Appeal Decisions

Appeal A Ref: APP/R5510/C/24/3348551

27 Eastbury Road, Northwood HA6 3AJ

Appeal B Ref: APP/R5510/W/24/3347534

DRWG NO A871-1

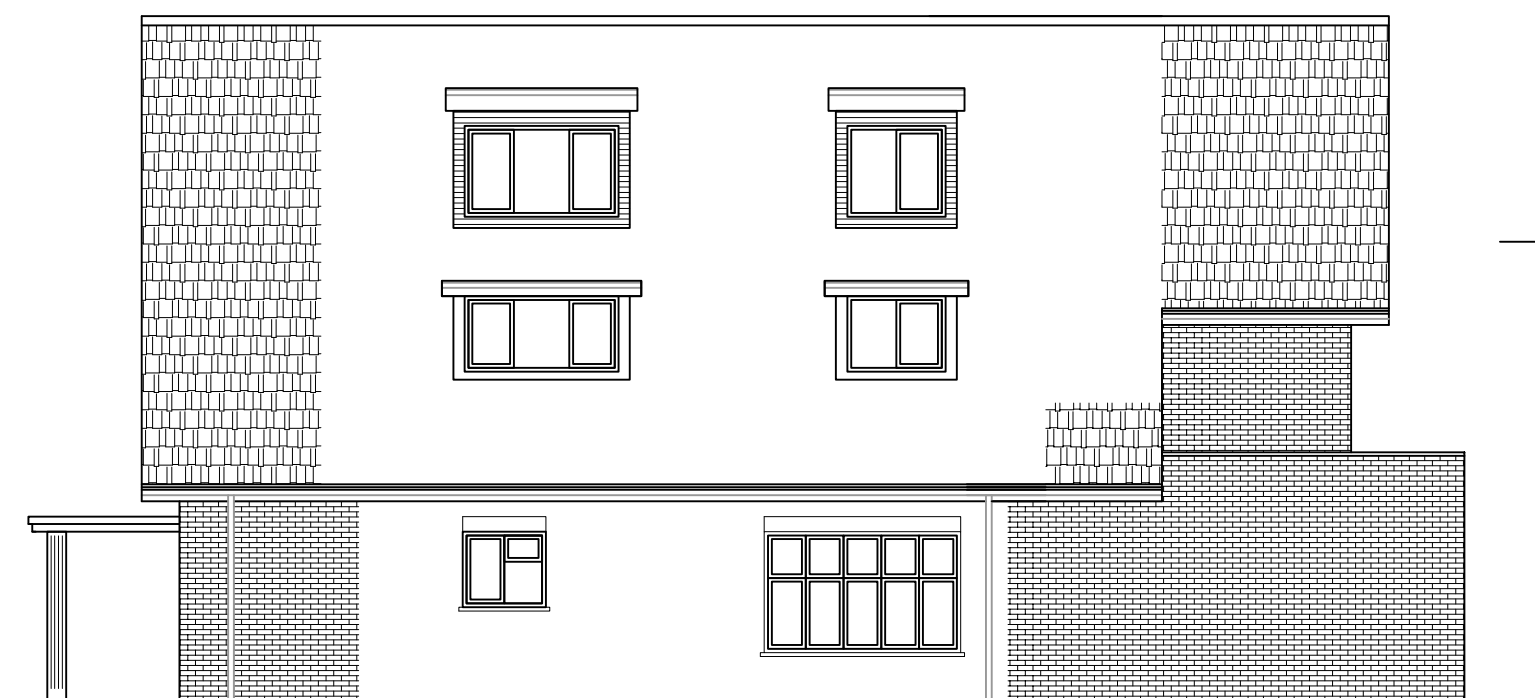
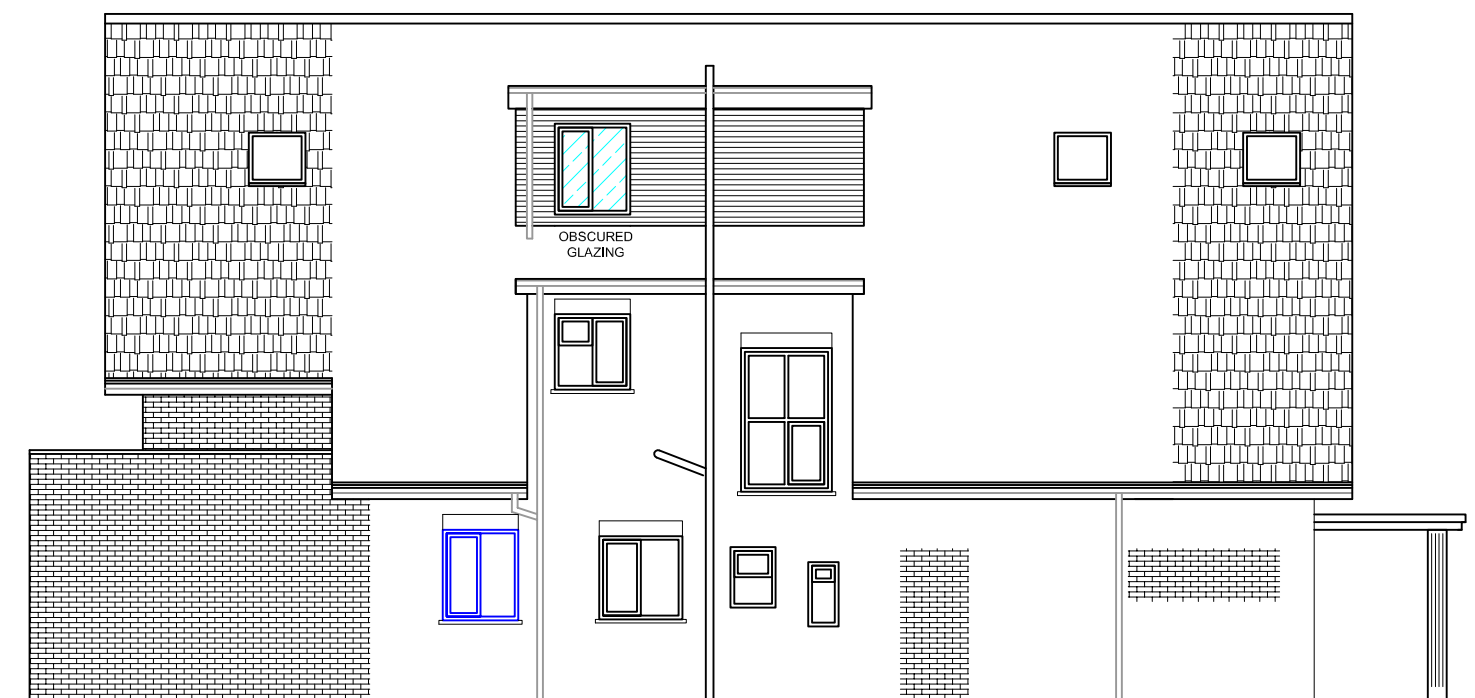
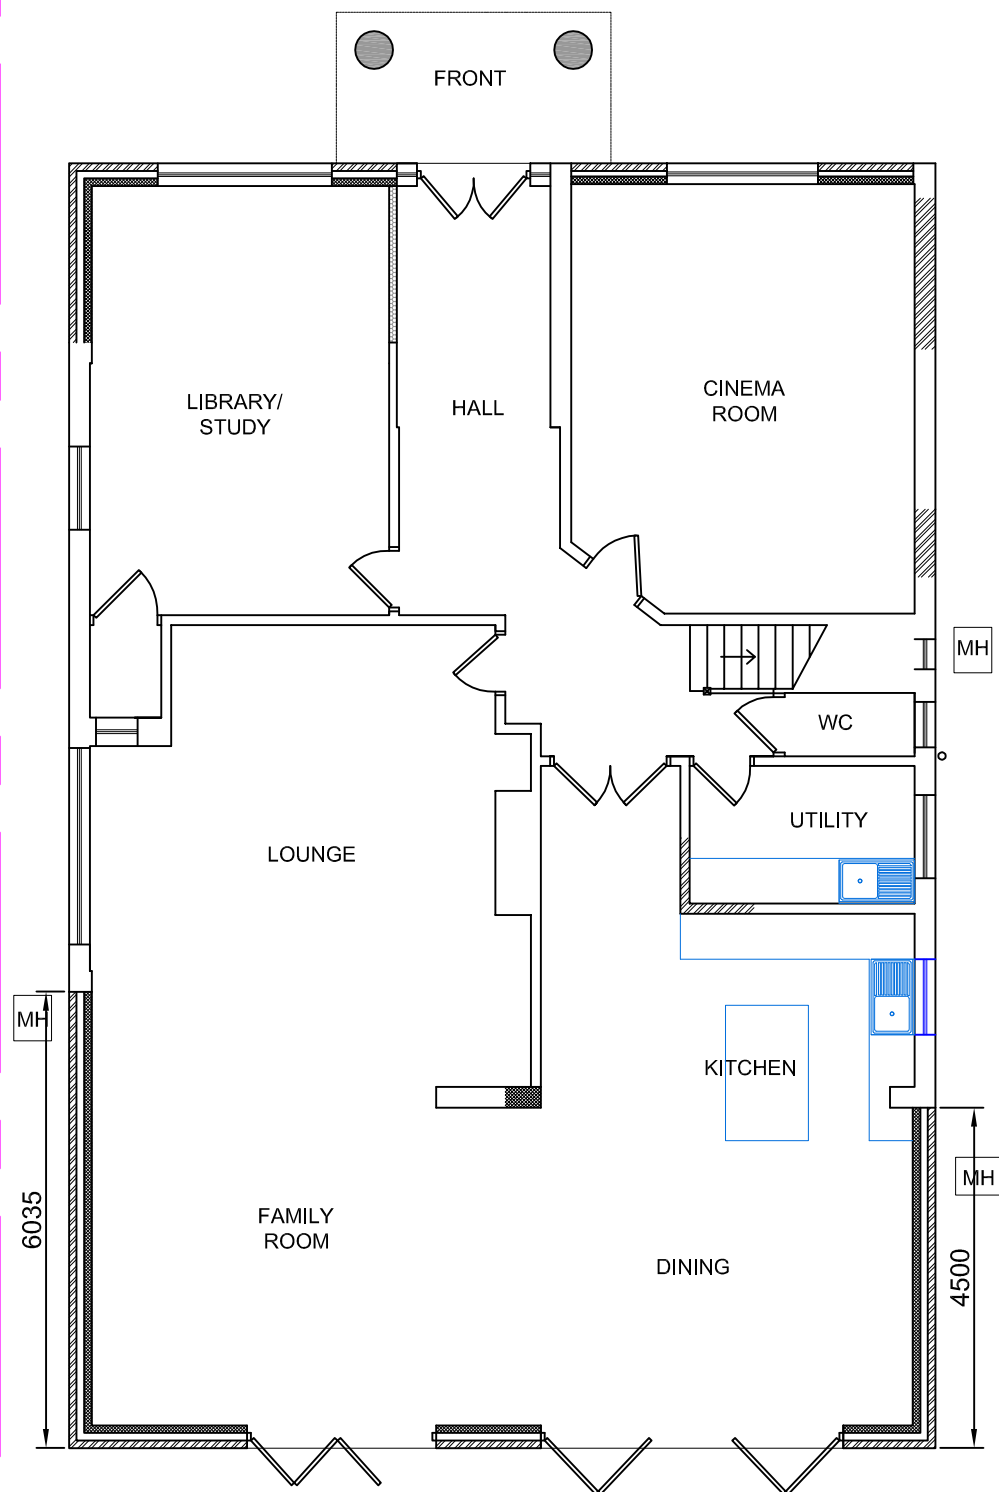
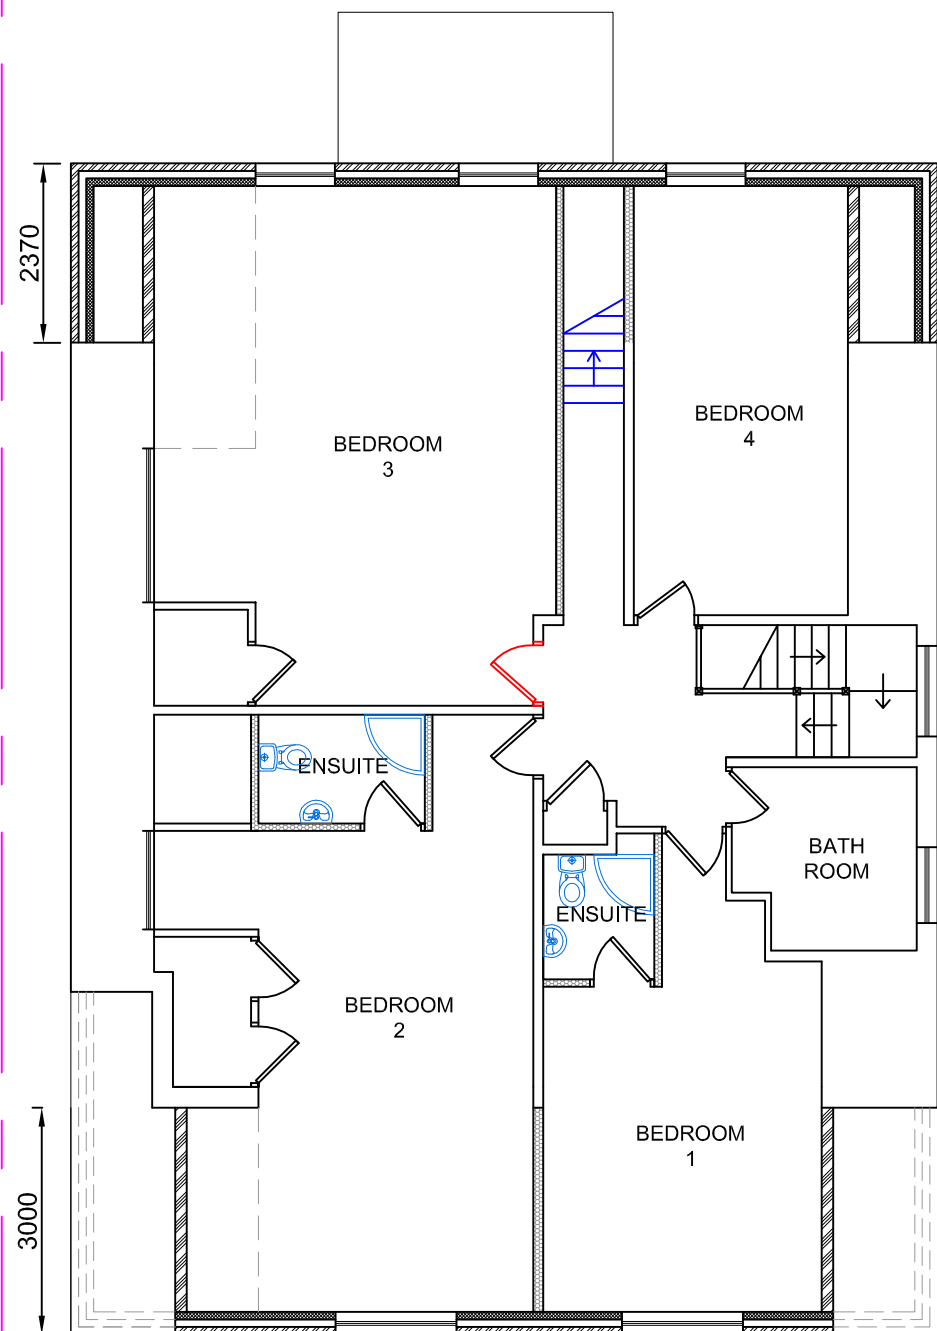
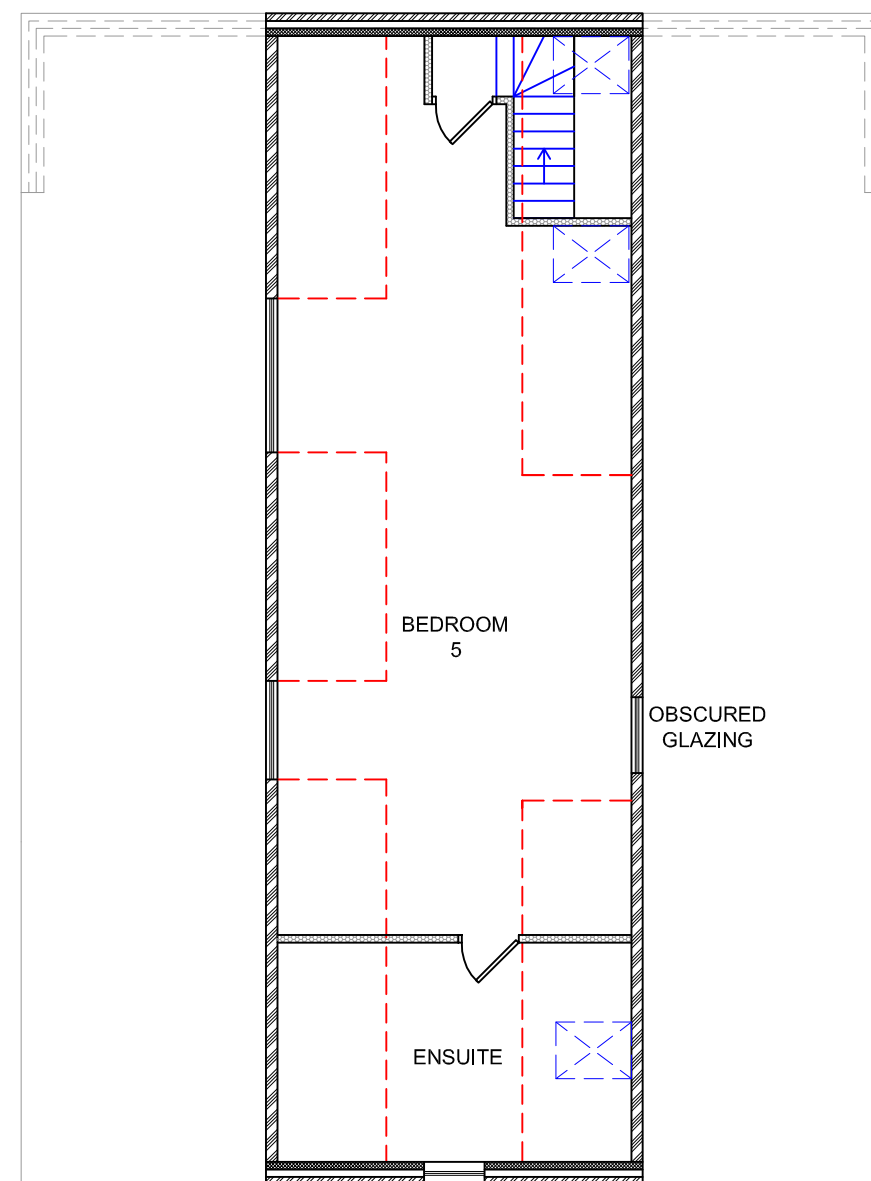
- (ii) modify the façade to be in accordance with drawing no. A871-1, dated (Dec 2019), approved by part allowed planning appeal decision reference: APP/R5510/D/20/3250793 dated 29 October 2020 (LPA planning application reference: 75352/APP/2020/183); including change to fenestration arrangement and windows in terms of size, location and materials, add white banding over the converted garage, and change bargeboard to match colour (white).

- (iii) replace all materials used in the construction of the external surfaces of the dwelling to match details as shown on drawing no. A871-1, dated (Dec 2019), approved by part allowed planning appeal decision reference: APP/R5510/D/20/3250793 dated 29 October 2020 (LPA planning application reference: 75352/APP/2020/183); including, replacement of all window and door frames to white UPVC frames, replacement of barge boards and fascias to white, and replacement of roof tiles to interlocking red concrete tiles.

- (iv) remove all roof lights and replace with three south facing roof lights at loft floor level in accordance with details shown on drawing no. A871-1, dated (Dec 2019) in terms of location, size and materials, approved by part allowed planning appeal decision reference: APP/R5510/D/20/3250793 dated 29 October 2020 (LPA planning application reference: 75352/APP/2020/183).

- (v) modify the side roof dormers at first floor to match original in terms of external materials, including replacement of tiles on all surfaces to interlocking red concrete tiles in accordance with the details approved under part allowed planning appeal decision reference: APP/R5510/D/20/3250793 dated 29 October 2020 (LPA planning application reference: 75352/APP/2020/183).

- (vi) complete the front porch to be in accordance with the approved plans found in part allowed planning appeal decision reference: APP/R5510/D/20/3250793 dated 29 October 2020 (LPA planning application reference: 75352/APP/2020/183).
